# **Lower Thames Crossing**

**The Examining Authority's Written Questions and Requests for Information (ExQ3) –**

**Thurrock Council Responses**

**5 December 2023**

Drawing file: TR010032 / TR010032-003754-DL4 - Kathryn Homes Limited, Runwood Homes Limited, Runwood Properties Limited - Whitecroft - Site Plan.pdf

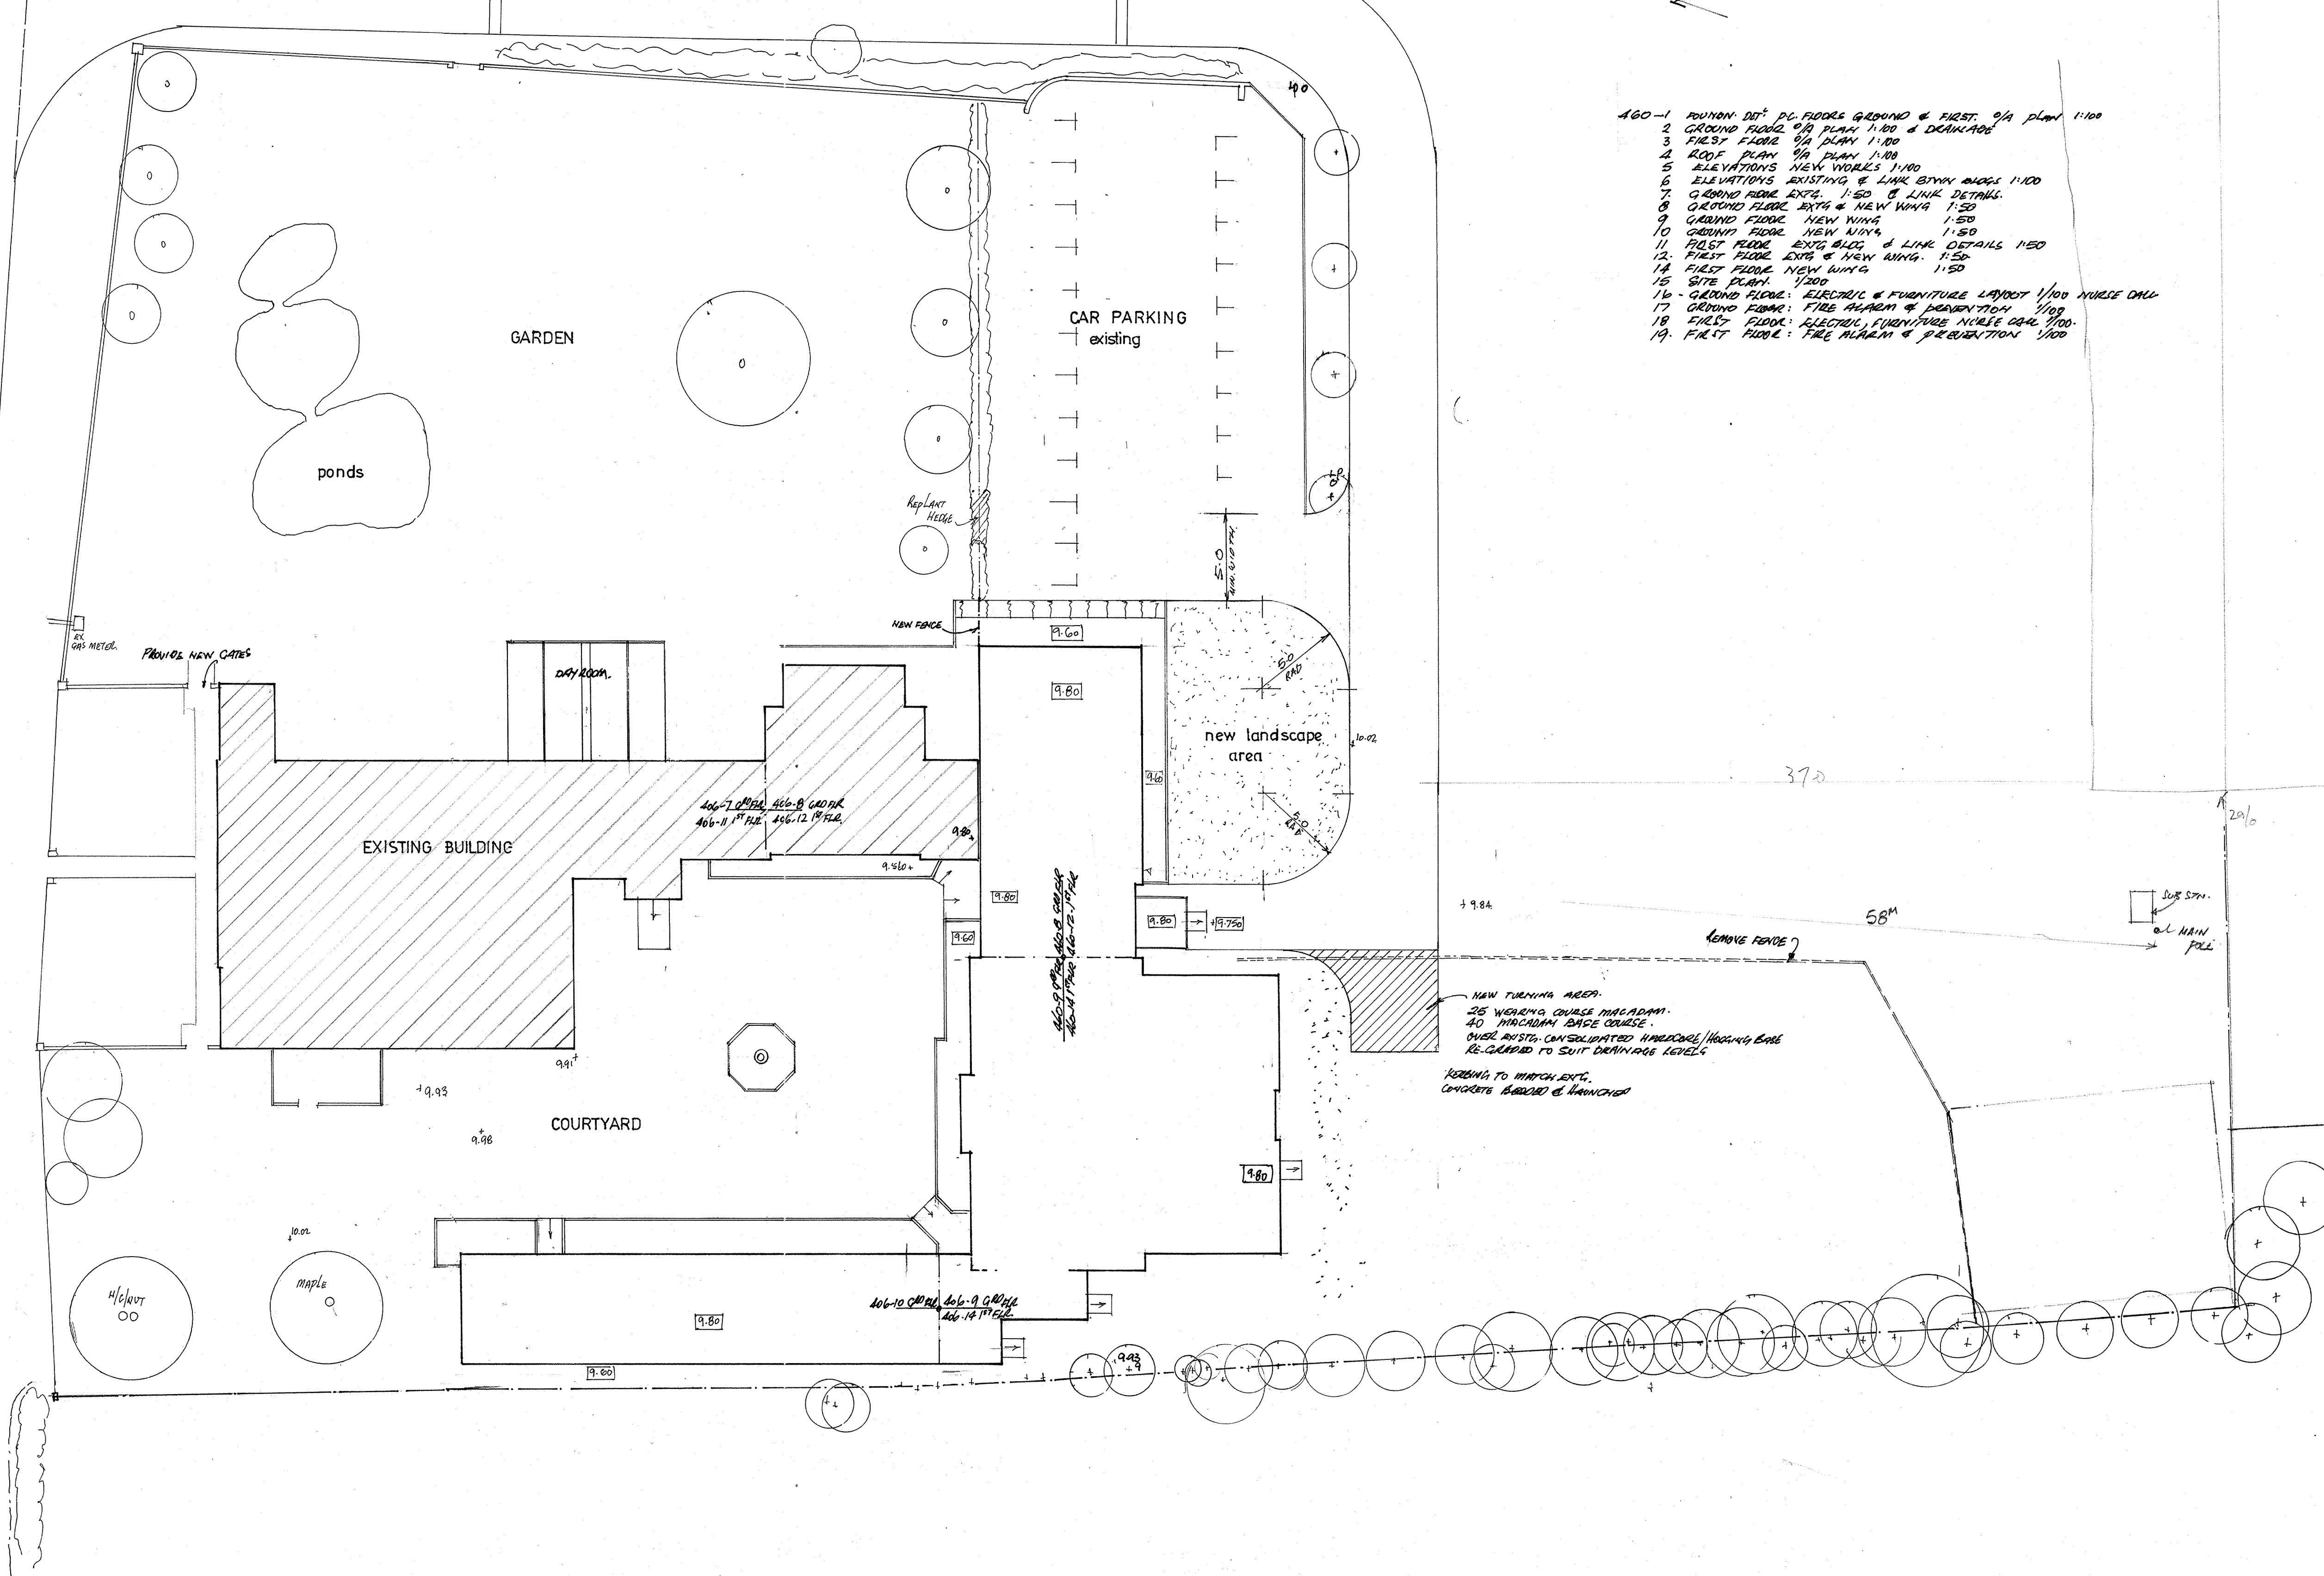
The Council have some recommendations relating to Whitecroft Care Home and the associated cross-sections ([REP5-092](#)). The proposed Infiltration Swale shown on Section B-B is confined within the A1013, the Project Alignment and the A13 earth mound. On the cross-section the Swale is described as a drainage ditch: however on Sheet 29 of the Drainage Plans Volume C ([REP7-076](#)) correctly describe the feature as a Swale. The Drainage Plans also show an Infiltration Basin, but this is not indicated on the cross-sections.

The Council request additional cross-sections to be produced to show the Infiltration Basin. Furthermore, the Cross-Sections need to be updated to use the same terminology as the Drainage Plans. Cross referencing to Work No. Will also be needed. This will also help in the response to ExQ3 Q10.1.1 regarding the question about Residual Risks and Exceedance routing for the Infiltration features.

**The Council request an update to the Cross-Sections ([REP5-092](#)), to show a section through the proposed Infiltration Basin and also to show consistent terminology with the Drainage Plans ([REP7-076](#)), and referencing of Work No. for each drainage feature.**
